CUMBERLAND
CITY COUNCIL

25 June 2020

**CUMBERLAND CITY COUNCIL SUBMISSION ON THE SYDNEY METRO WEST
ENVIRONMENTAL IMPACT STATEMENT (SSI-10038)**

Figure 20-1: Potential contamination risk (moderate rating and above) – Westmead metro station construction site and tunnel alignment

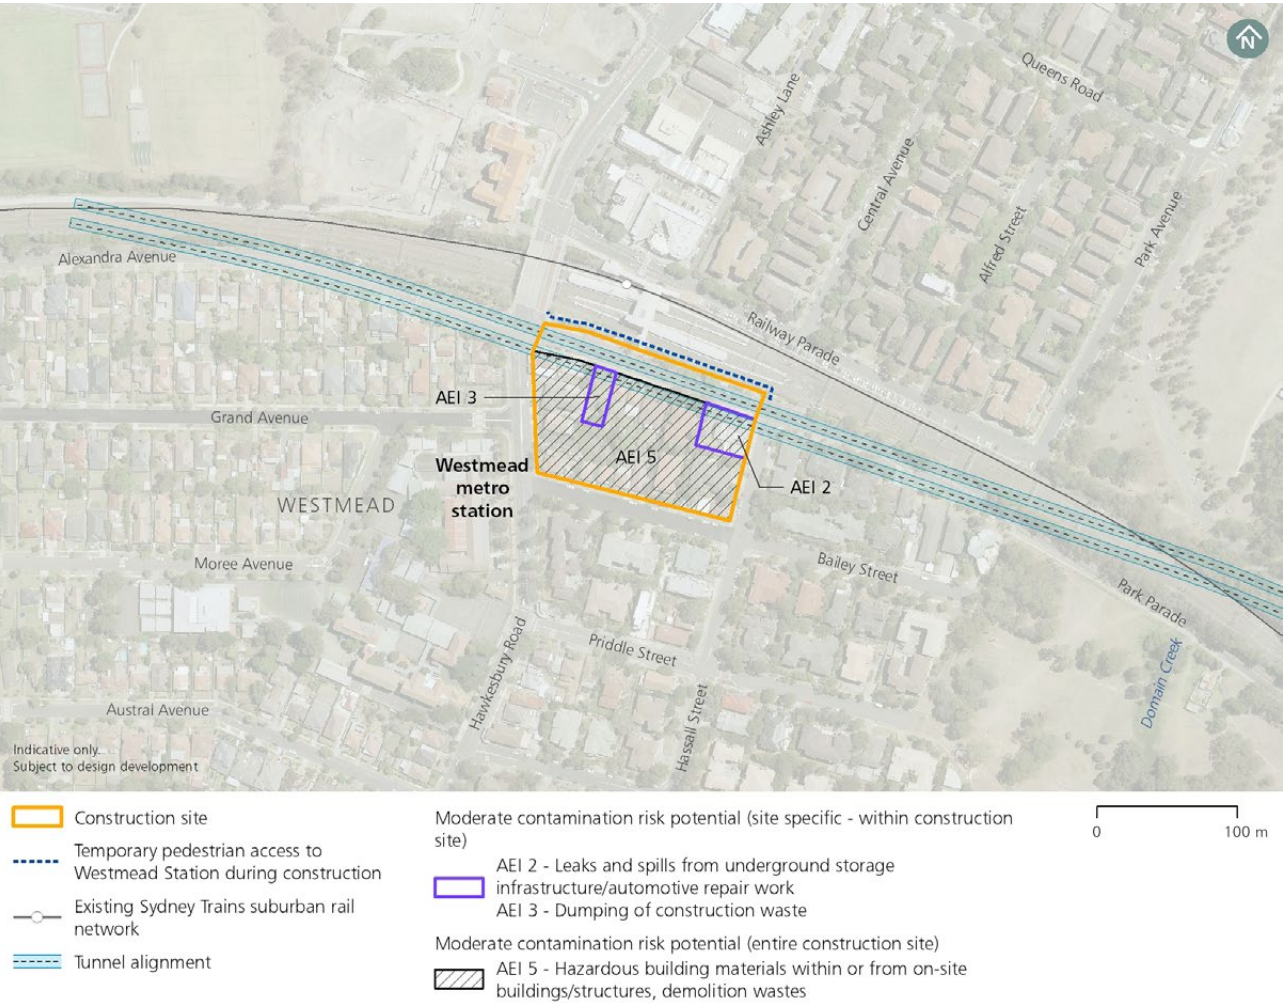
Based on the current information available to the consultant, Council is satisfied with the submitted Contamination Report (Tech Paper 8) in its form as a Preliminary Site Investigation and that it complies with the requirements of the Standard Secretary's Environmental Assessment Requirements (SEARs) so far. It is expected that any further detailed investigations/remedial actions will be undertaken in compliance with the recommendations of this report as well as all other relevant NSW contamination guidelines written or endorsed by the NSW Environment Protection Authority.

Figure 9-12: Westmead metro station indicative construction site layout

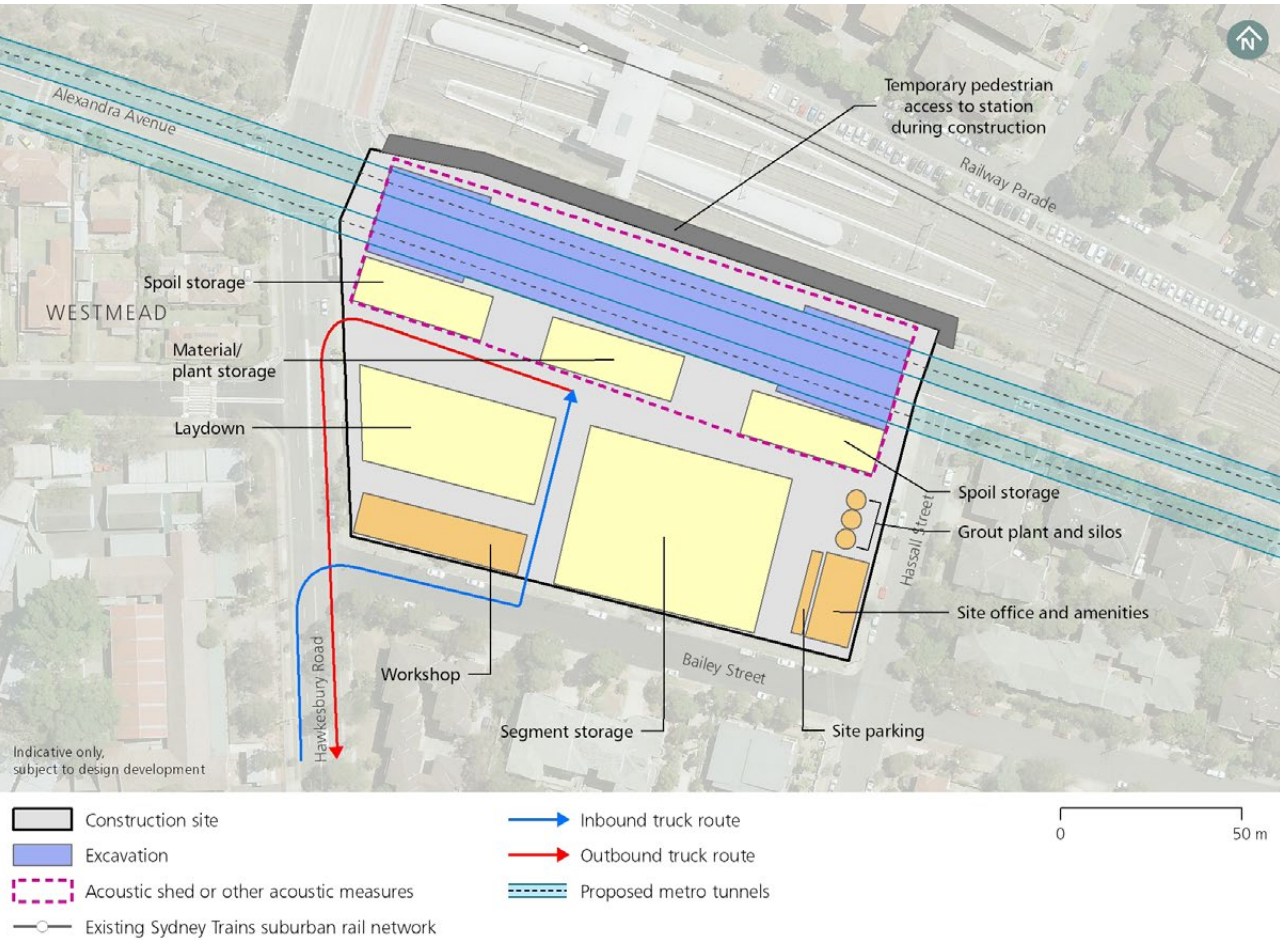
Council acknowledges Sydney Metro's efforts to avoid and minimise potential transport and traffic impacts of Stage 1 through the proposed haulage route that will use Hawkesbury Road to access the M4 Western Motorway to the south. Council acknowledges that this route will minimise the use of local roads, and it is an efficient route to the arterial road network. However, significant impact is expected on the immediate surrounds of Hawkesbury Road, particularly Westmead Public School, due to the altered traffic arrangements. The impact on the safety of students and parents due to increased traffic should be carefully considered and steps taken to address this in a timely and collaborative manner with the school and Council.

Council notes Sydney Metro's consideration of the likely impact on emergency response services (particularly those travelling to and from the Westmead health precinct) due to the closure of Alexandra Avenue and diversion onto Bailey Street and Hassall Street. Council welcomes Sydney Metro's plans to consult emergency services (Ambulance, Fire & Rescue and Police) about the proposed road network changes during construction.

Although the daily and peak light and heavy vehicle movements likely to be generated are identified in the EIS for four phases, further discussion is required on its potential impacts on the local and regional traffic network during the various stages of construction. Further clarification is also required on the anticipated durations of these phases/stages of construction, and how they would overlap.

Figure 9-13: Westmead road realignment works

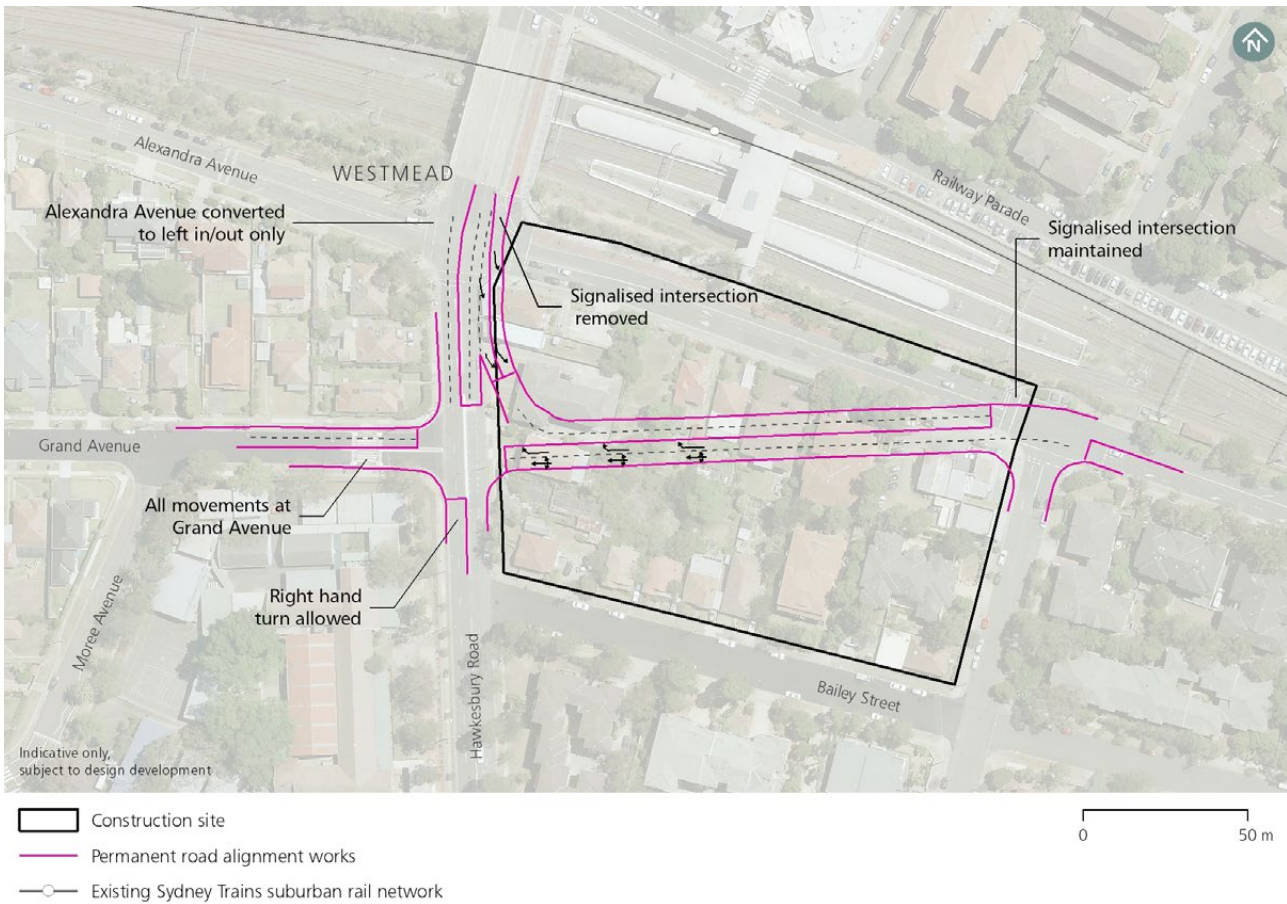
The EIS notes that after the station excavation and tunnelling works have been completed, Alexandra Avenue would be permanently realigned to form a new intersection at Hawkesbury Road with Grand Avenue. Council has reviewed the traffic modelling carried out for the anticipated performance of key intersections in the year 2023 with and without Stage 1, for this permanent road network arrangement. It is noted that an improvement in intersection performance is expected at several intersections. Some intersections, however, would experience a reduced level of service.

The intersection at Alexandra Avenue/Bridge Road, however, is expected to experience a reduction in level of service during the morning and evening peak hour from B to C and E to F respectively. Although this intersection would still operate with spare capacity in the morning peak, significant congestion is expected during the evening peak.

The EIS notes that the impact in the evening peak at the Alexandra Avenue/Bridge intersection is due to additional vehicles travelling along Grand Avenue, and the Grand Avenue/Bridge Road intersection accommodating a higher number of vehicles with increased queue lengths on most approaches. This would result in congestion on the westbound approach of the adjacent Alexandra Avenue/Bridge Road intersection.

The EIS does not, however, identify any measures to minimise or mitigate the reduced level of service at the Alexandra Avenue/ Bridge Road intersection nor include an assessment of available options and the expected effect of the measures proposed. Council therefore recommends Sydney Metro consult with Council and relevant parts of Transport for NSW in a timely manner, as noted in the EIS, to identify appropriate measures to mitigate the impacts at this intersection.
